Summary of contribution to CAH1.

Data: IGP, 2025
Base Maps: © Crown copyright and database rights 2023 Ordnance Survey 0100031673
Imagery ©2024 Landsat / Copernicus, Maxar Technologies, Map Data ©2024

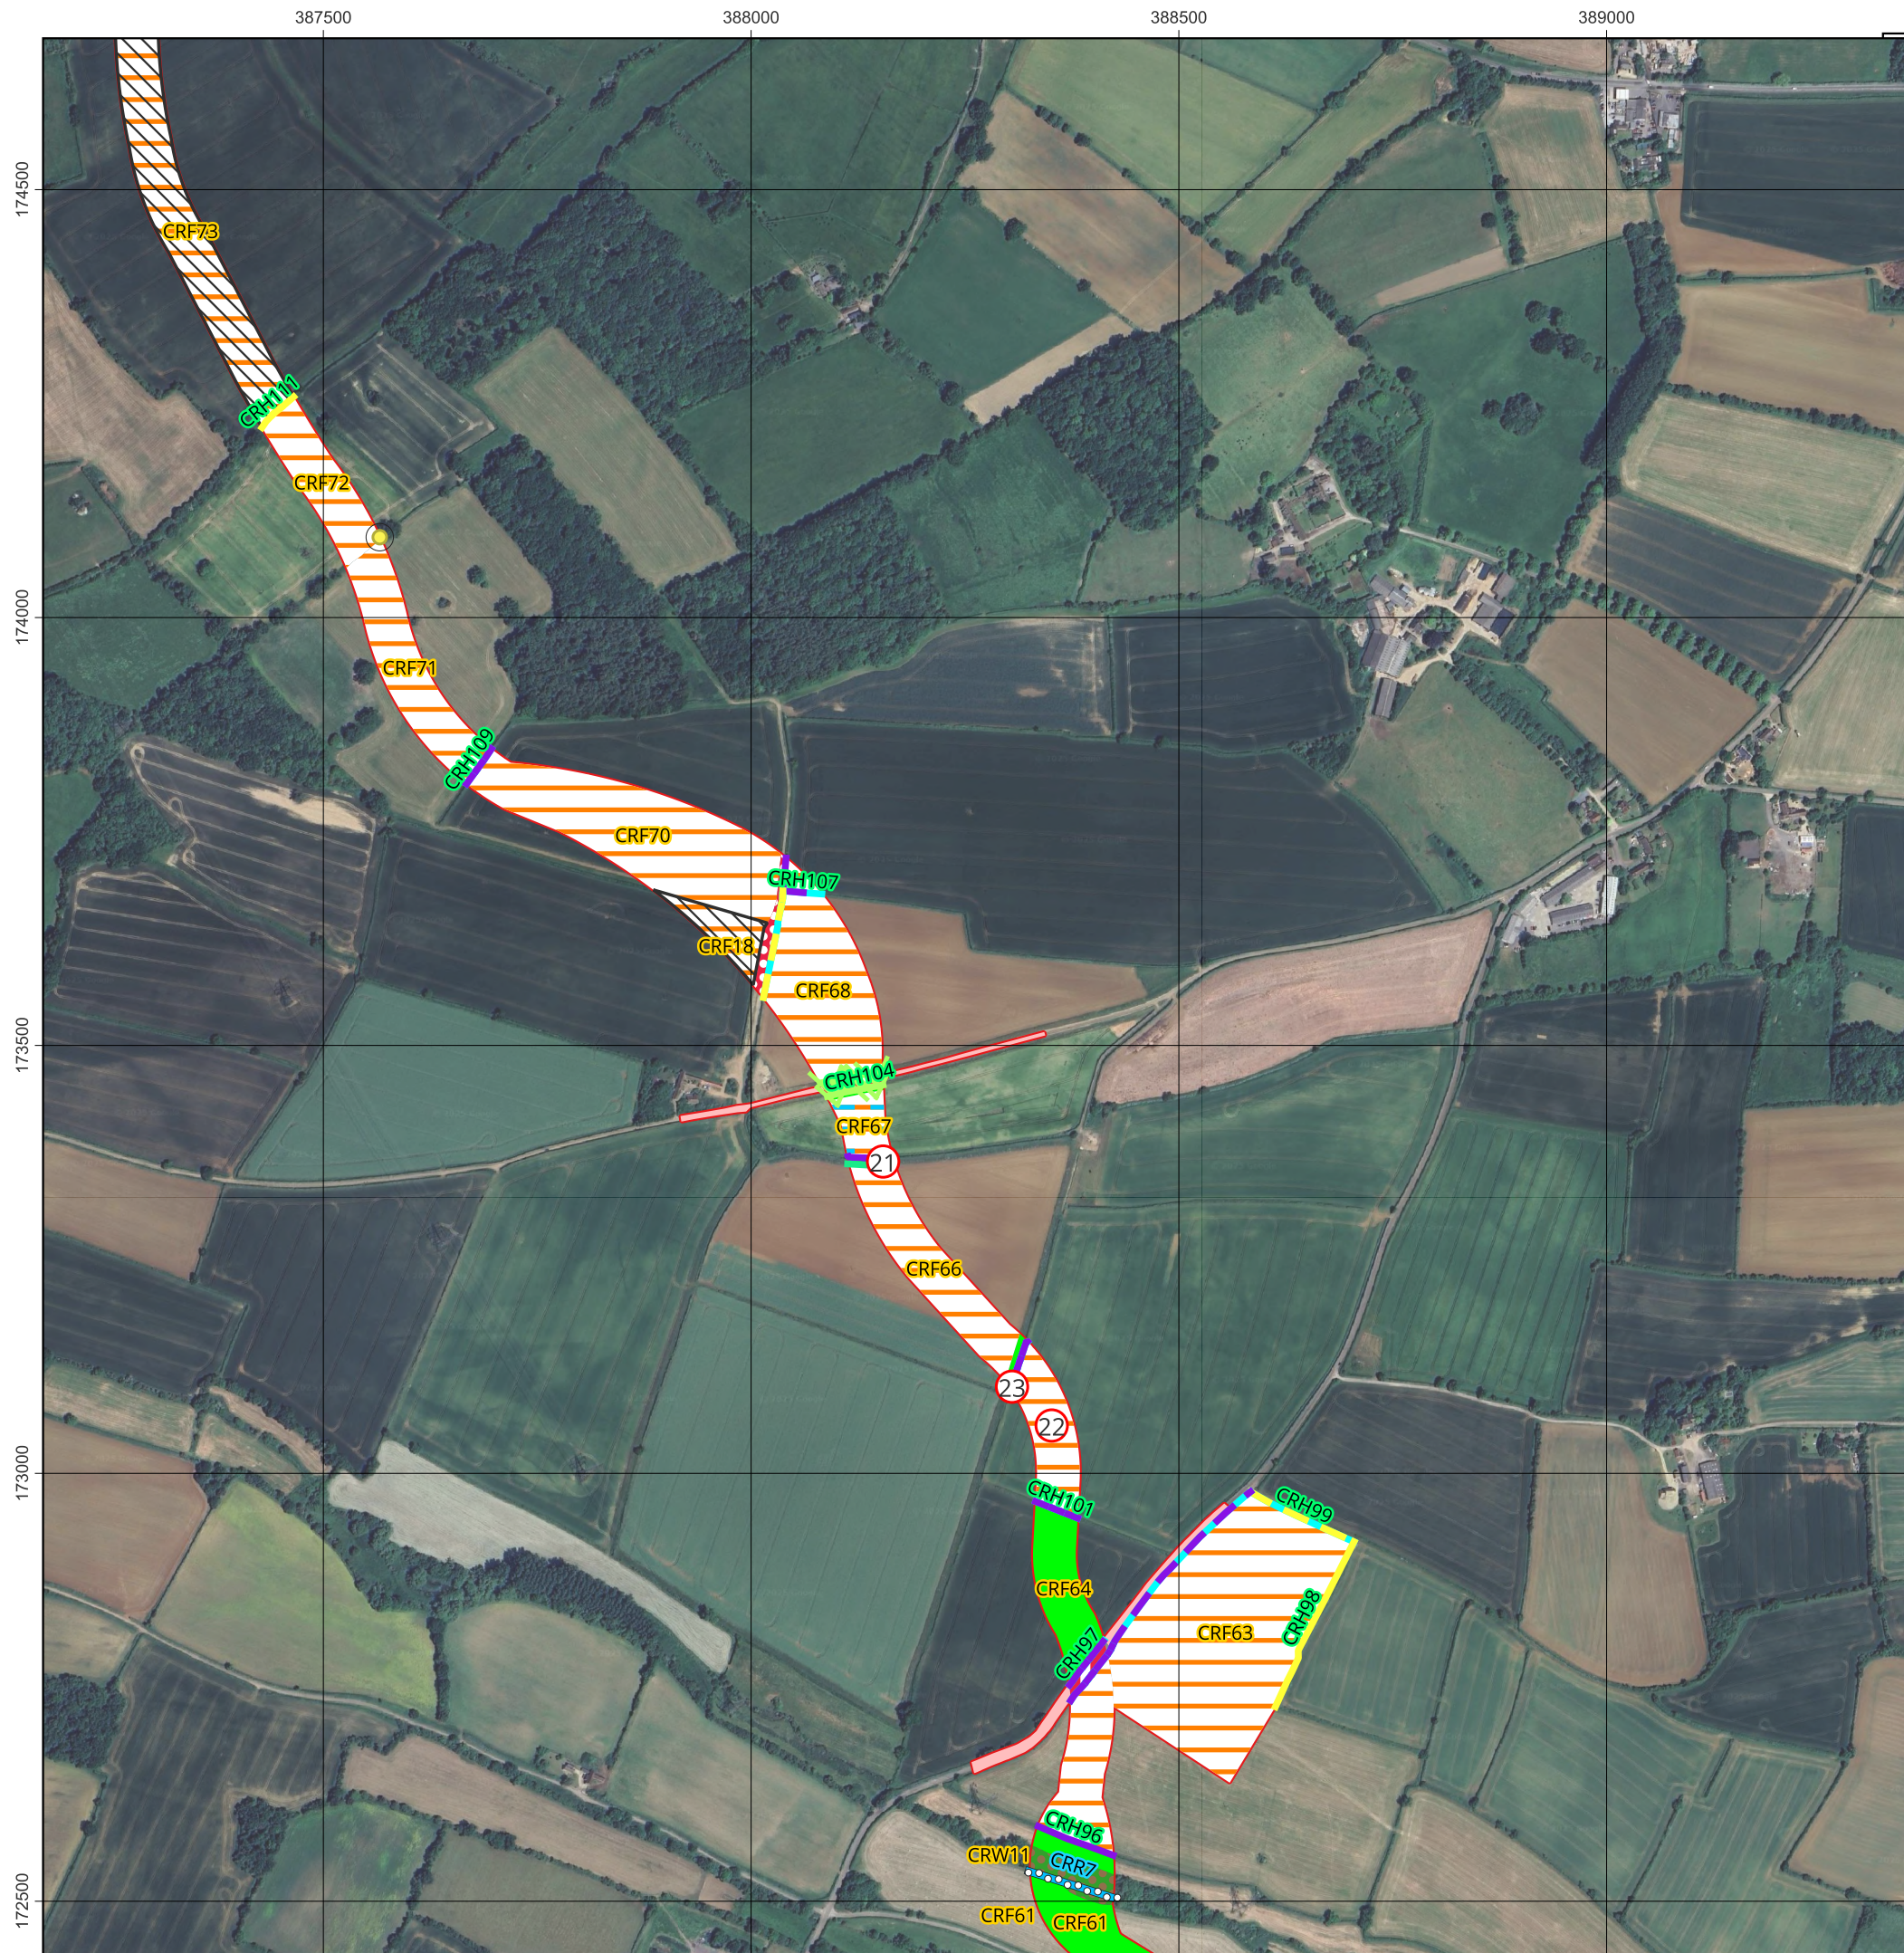
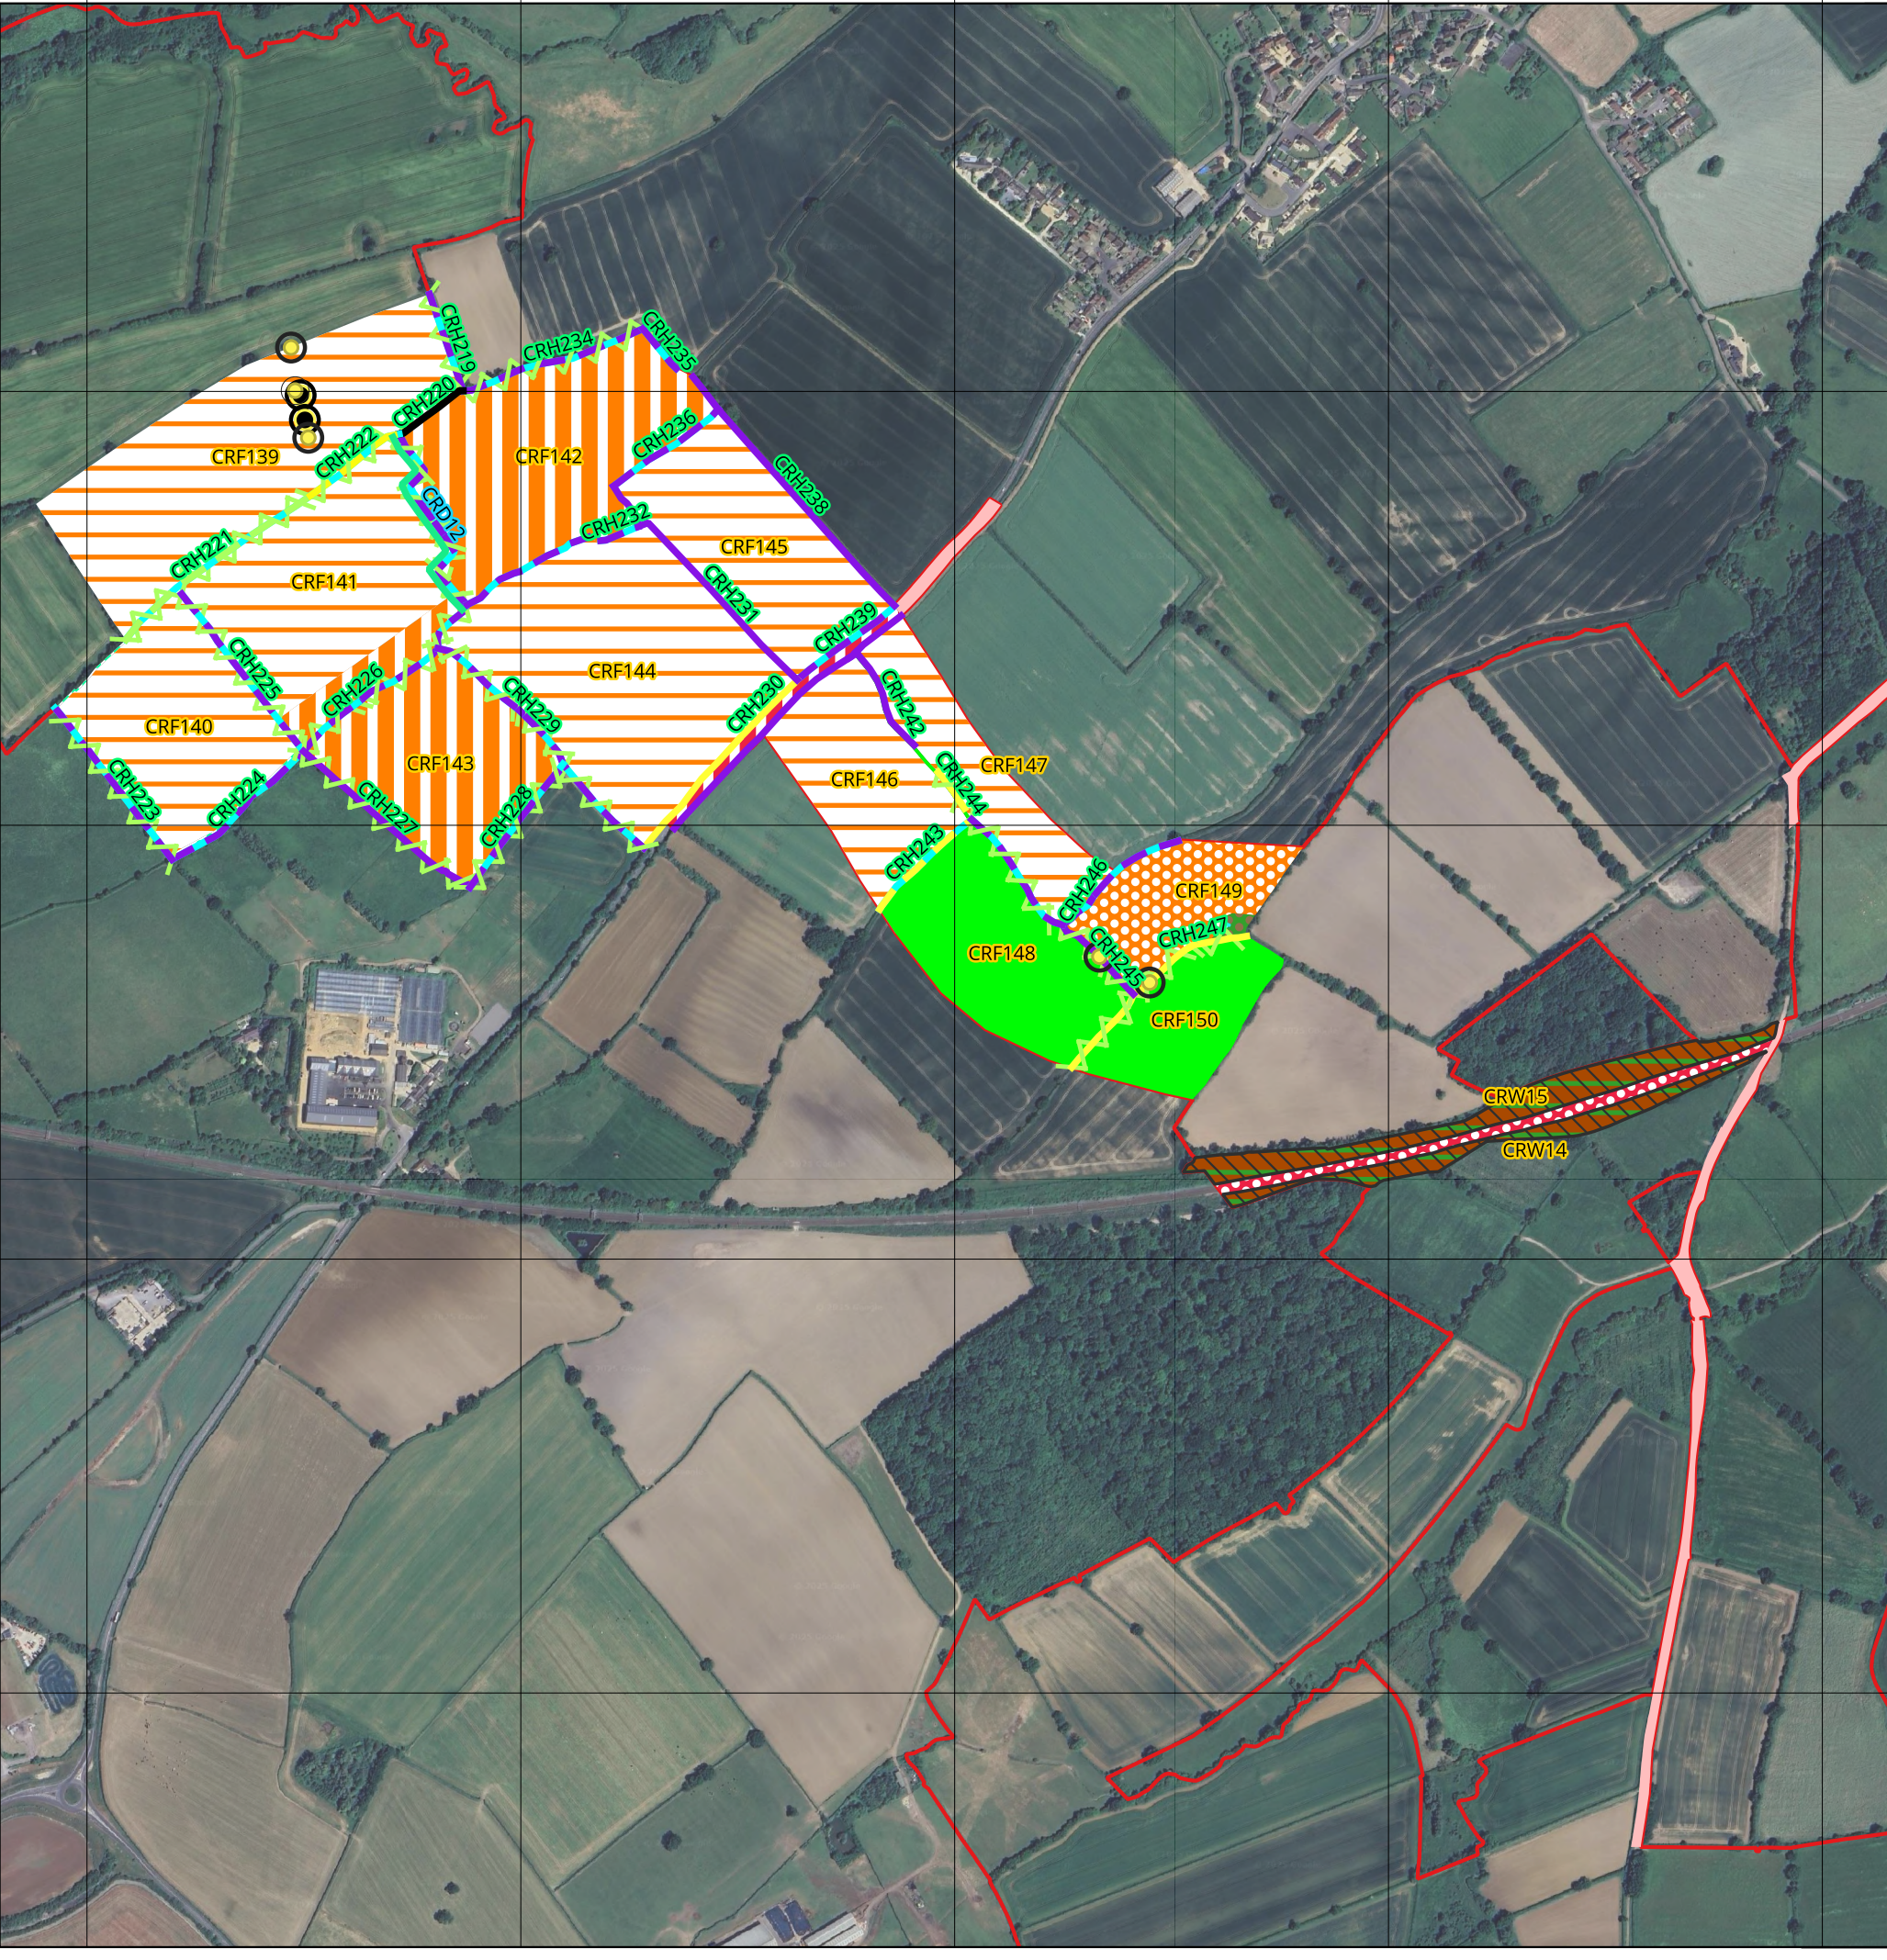
A further observation revolves around the Baseline habitat map and the designation of non-cereal crop and cereal crop. I'm wondering if there is any meaning to these criteria? Clearly the designation was recorded at the time of the survey but it is now incorrect, due to crop rotation. Are there conclusions drawn from this data?
